Subject: **Western Coal Services (SSD 5579) – MOD 4 RTS**

Detailed advice to DPE Planning & Assessment regarding the Western Coal Services (SSD 5579) Mod 4 RTS

Figure 1: Modification 4 Elements

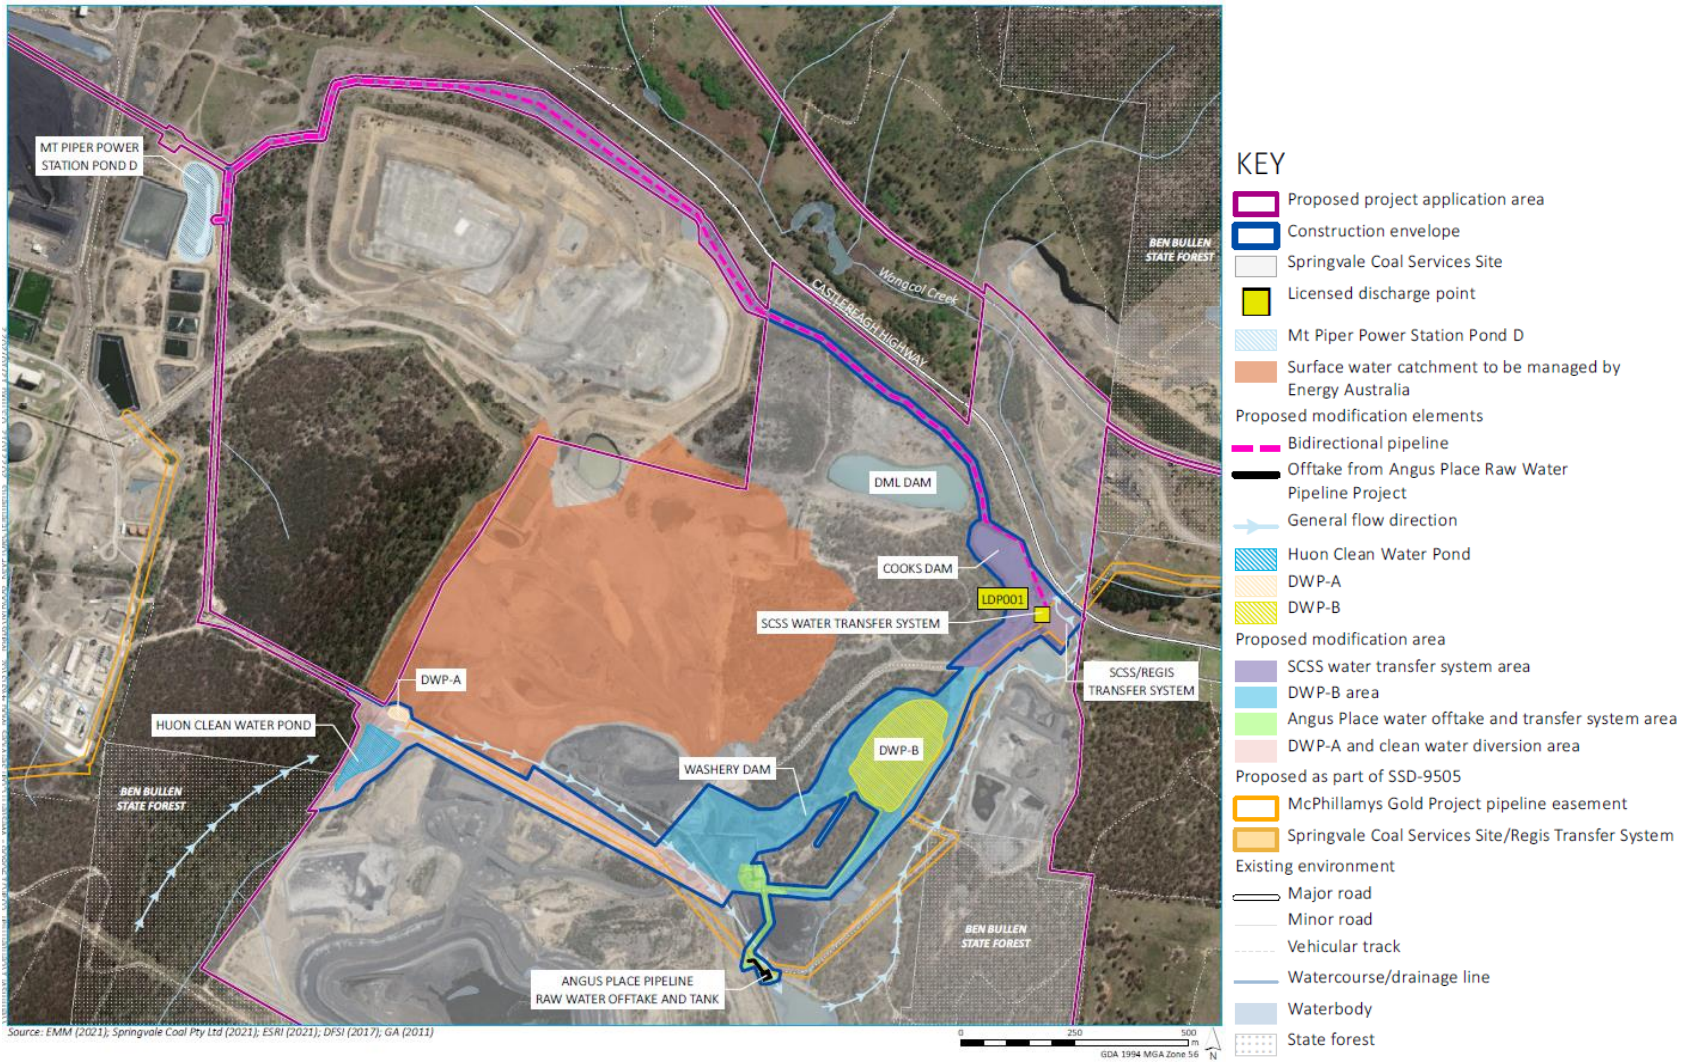
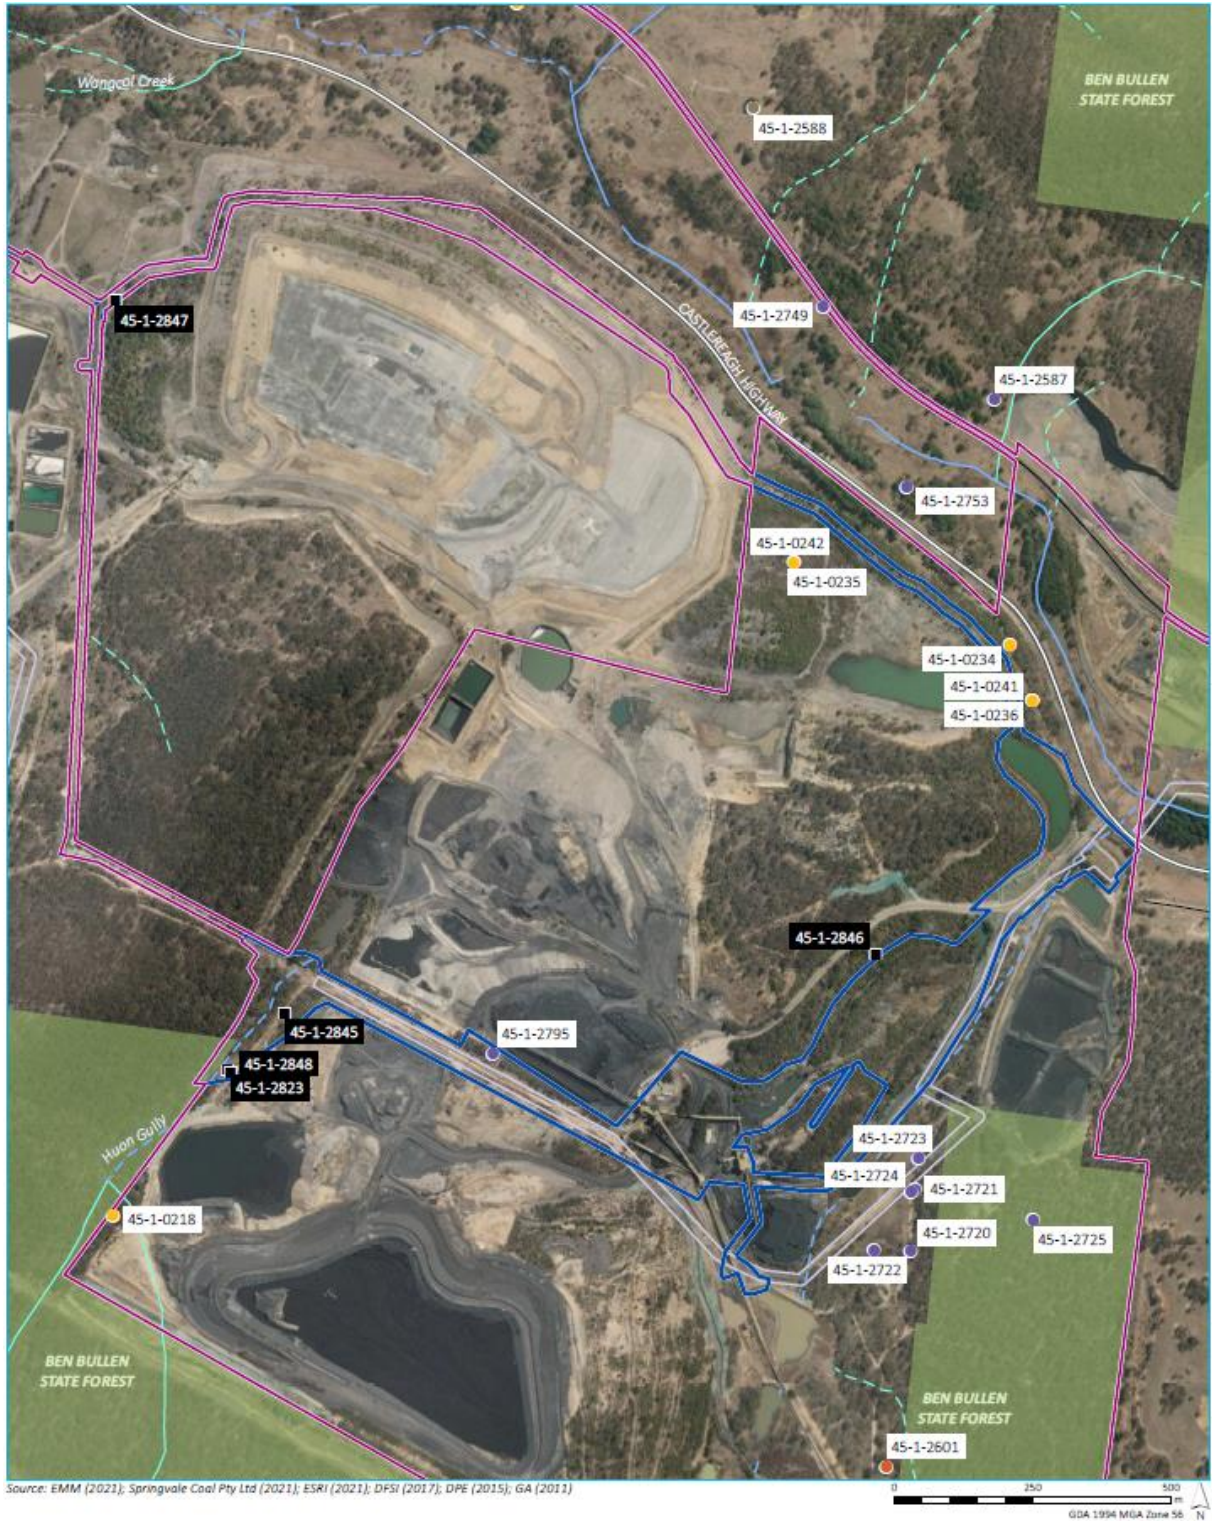
- The department maintains its position that water entitlement is required to account for water take from both the Huon Gully Clean Water Pond (137ML/yr) and DWP-A (15ML/yr). We consider that the water is taken when pumped from the storages, and although it may later be returned to the water source, the original take needs to be accounted for through a licence. This requirement raises a significant risk to the project due to limitations on entitlement availability in the water source.
- Clarification is requested on the separation of clean and dirty water in the clean water diversion based on requirements for settling time prior to release from the main sediment pond.

That the proponent demonstrates sufficient surface water entitlement can be obtained for the projects water take from pumping water out of the Huon Clean Water Pond and DWP-A. The department advises there are significant limitations in entitlement availability in the relevant water source and recommends this be acknowledged as a significant risk and addressed prior to determination.

As both storages are to be located on third order watercourses and are within a water source, a Water Access Licence (WAL) with sufficient entitlement is required to account for water take when water is pumped out of these storages. Whether the water is returned to the water source does not remove the requirement to account for the original water take. Based on the water balance model, a maximum of 137ML/yr and 15ML/yr is predicted to be pumped out from the Huon CWP and DWP-A respectively. The need to hold entitlement for this water take was raised in the department's response to the EIS and is yet to be adequately addressed. Significant limitations on water entitlement availability as highlighted in our response to the EIS indicate a significant risk of not being able to acquire the necessary entitlement. There are currently 211 units of issued entitlement in the relevant water source, of which 145 units are held in a single WAL.

That the proponent provides further clarification on the management of clean and dirty water separation from the Huon CWP into Lamberts Gully. This is to assist in addressing a query originally raised on review of the EIS.

The EIS and the RTS indicates clean water will be diverted from the Huon Clean Water Pond to the Main Sediment pond and then released into Lamberts Gully. The department considers the Main Sediment Basin to capture dirty water from upstream as Section 3.5.3 of the EIS identifies this basin as part of the dirty water management system, with the requirement for water entering this basin to require settling time before discharge. If the water diverted from the Huon CWP is clean, it is recommended it be diverted directly into a clean section of Lamberts Gully. Alternatively, if all water captured in the Main Sediment Basin is clean, further clarification is required.
